## CHENNAI METROPOLITAN DEVELOPMENT AUTHORITY

Letter No. CMDA/PP/MSB/N/0354/2019

Sub: CMDA – APU – MSB(North) – Planning Permission Application is for the construction of **4 Multi – Storeyed Block A to D** each consisting of Stilt floor + 10 floors – Residential Building with 120 Dwelling units (Totally 480 Dwelling units); **Community Hall Block** : Ground floor Building; **Ration Shop Block** : Ground floor Building; **Convenient Shop Block** : Ground floor Building with 6 Convenient Shops at NTO Kuppam, Survey No. **139/1**, T.S. No. **1/1**, Block No. 2, Ward No. J of **Thiruvottriyur Village**, Thiruvottriyur Taluk, Thiruvallur District, Chennai applied by The Chief Engineer, Tamil Nadu Slum Clearance Board - Forwarded to Govt., for approval – Reg.

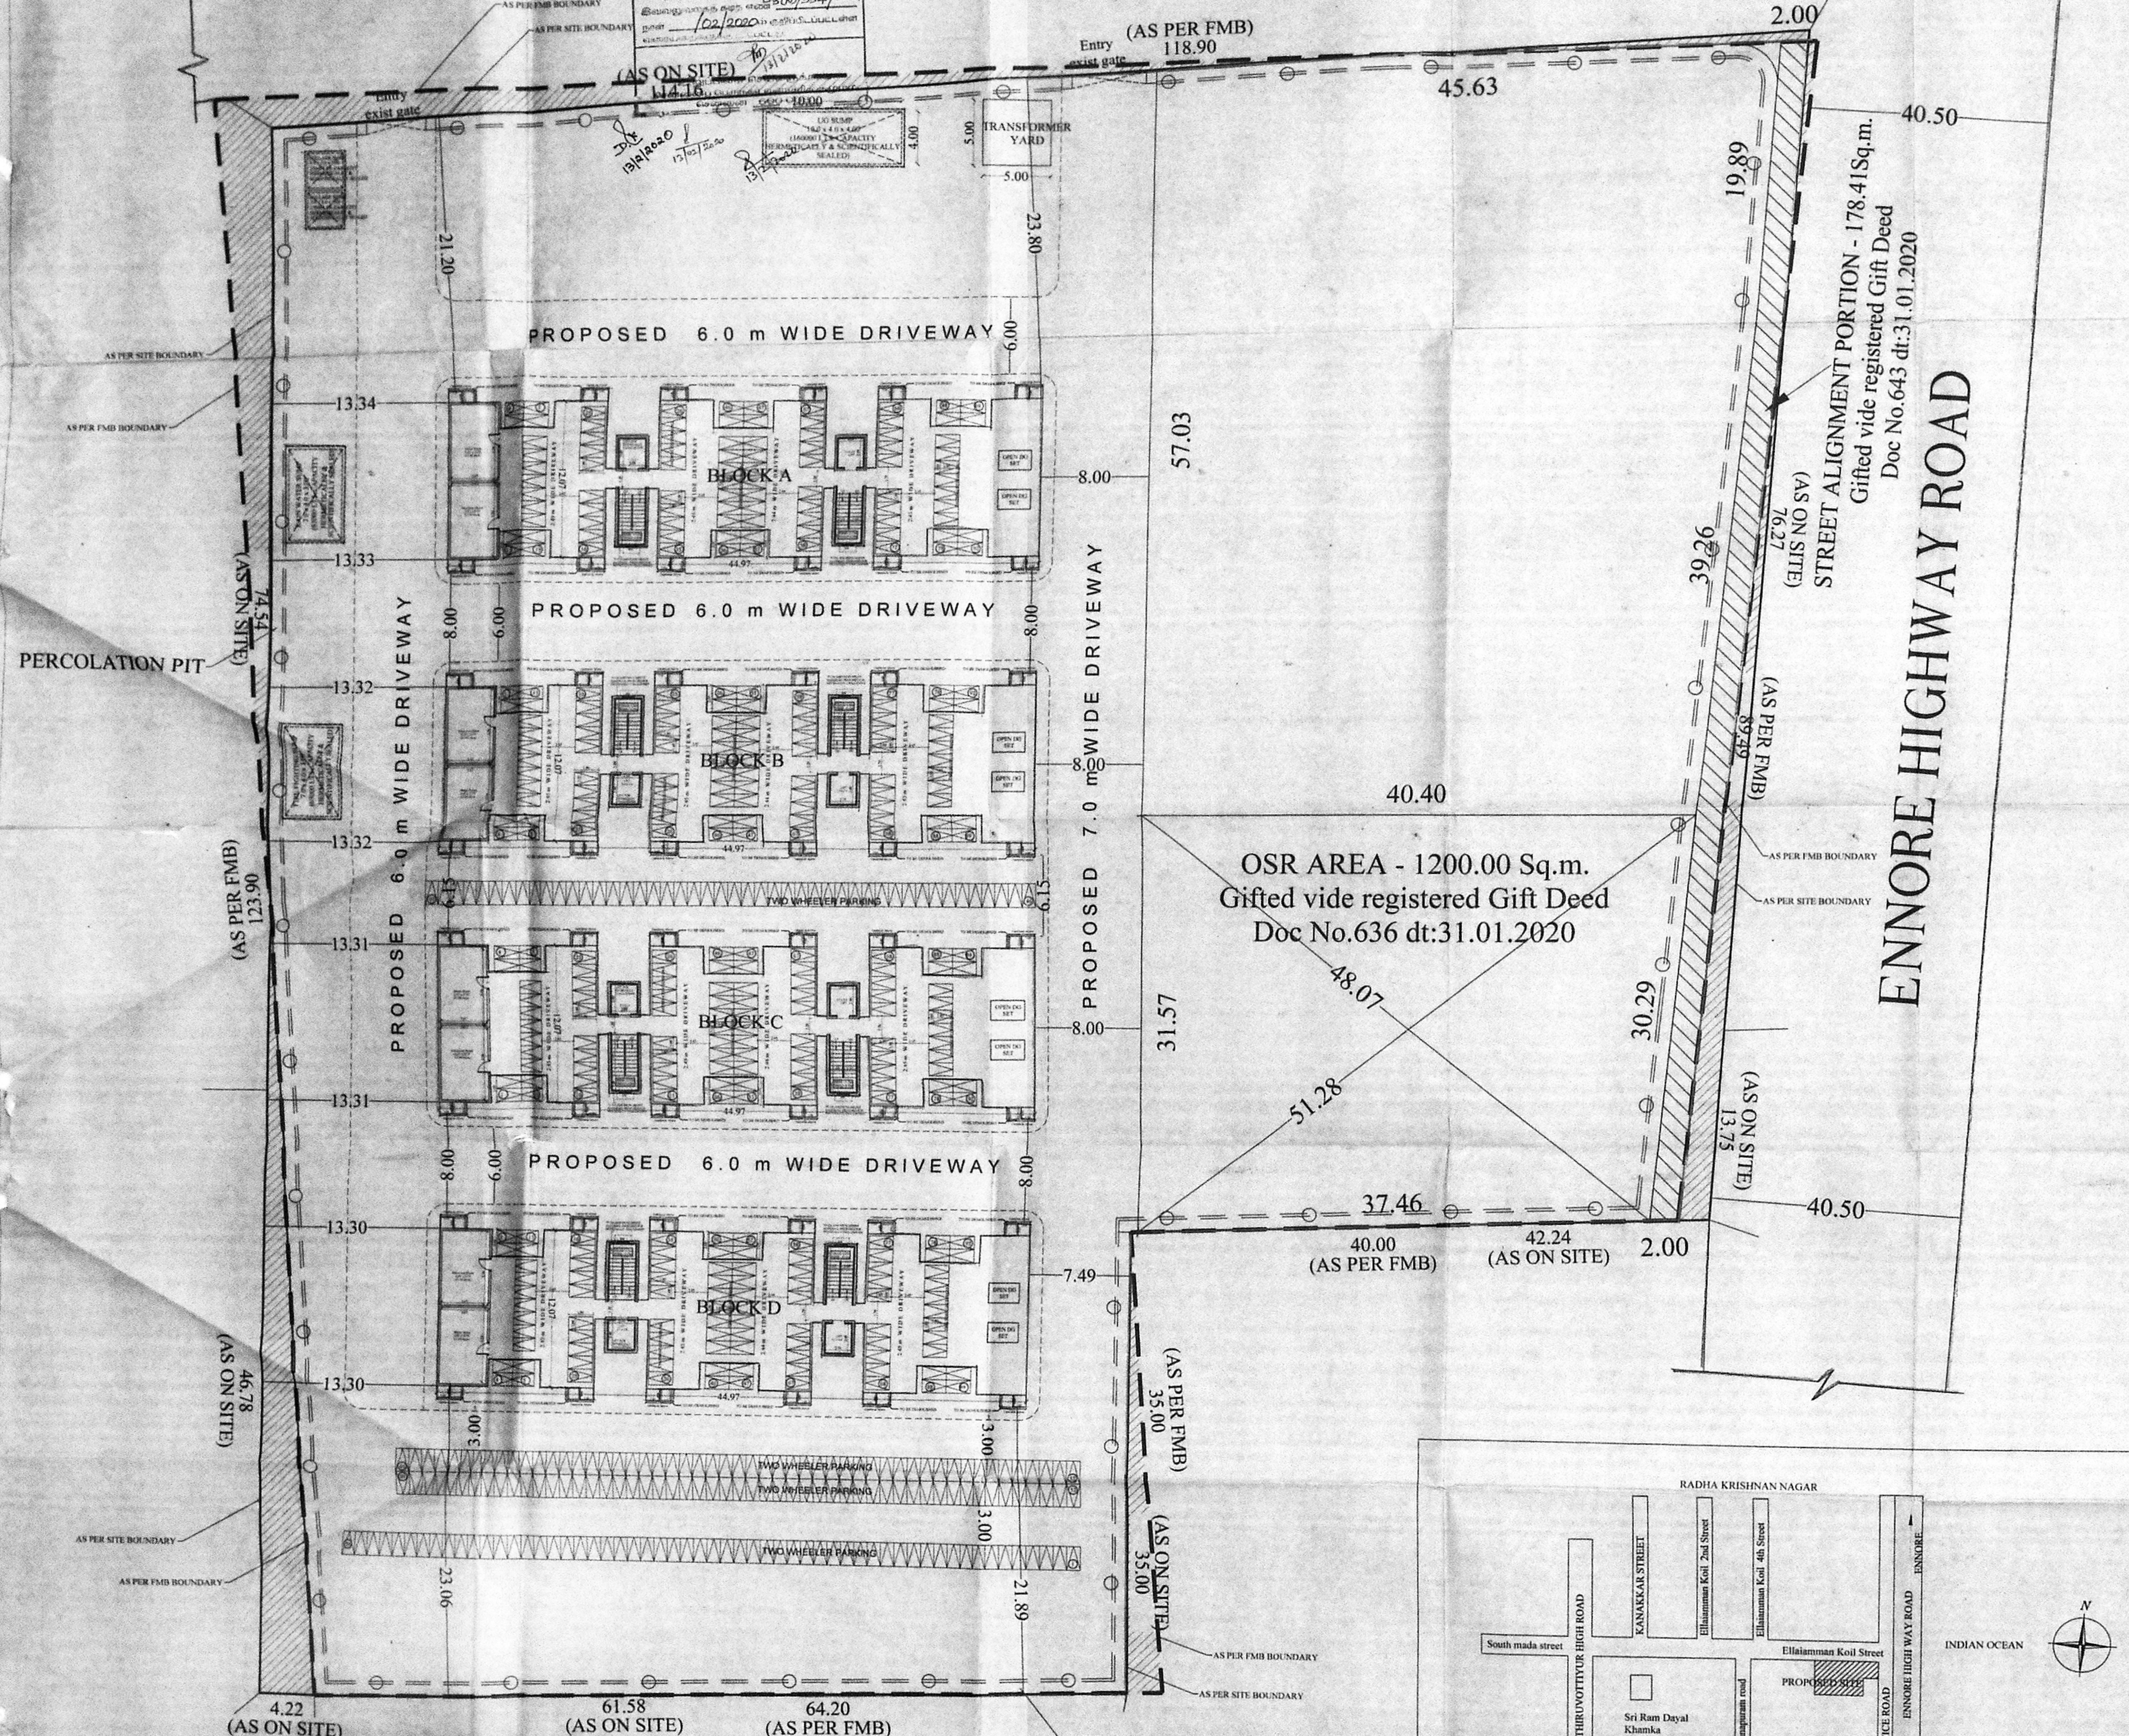
- 1) 5 set of Revised Plans rectifying the following drafting defects:
  - (i) Boundary as per FMB & Site to be superimposed and the difference in area to be distinguished with proper hatching. ✓

- (ii) Building & Setback dimensions do reflect the as on site condition and the same has to be rectified. ✓
  - (iii) Clear Setback measurement to be mentioned all crucial points in the site plan. ✓

- (iv) Clear Dimensions of the OSR area to be mentioned in the site plan. ✓
  - (v) Overall Building dimensions to be mentioned for all the Buildings in the site plan. ✓

- (vi) Percolation Pit to be shown for Rain water Harvesting as per TNCB&DR 2019. ✓
  - (vii) Existing Ground level to be mentioned in both Section & Elevation and Total Height of the Building including Lightning Arrester to be shown from the existing Ground level. ✓

- (viii) Section & Elevation requires correction with respect to individual floor plans of Typical Blocks. ✓
  - (ix) Sumps & OHTs for Firefighting & Sullage water recycle to be shown in the site plan. ✓

- (x) Proposal Title & Area Statement requires correction. ✓
- 2) Combined FMB sketch for Survey No. 139/1, T.S. No. 1/1,2, Block No. 2 of Thiruvottriyur village duly signed by the Revenue officials not below the rank of Deputy Tahsildar to be furnished. ✓
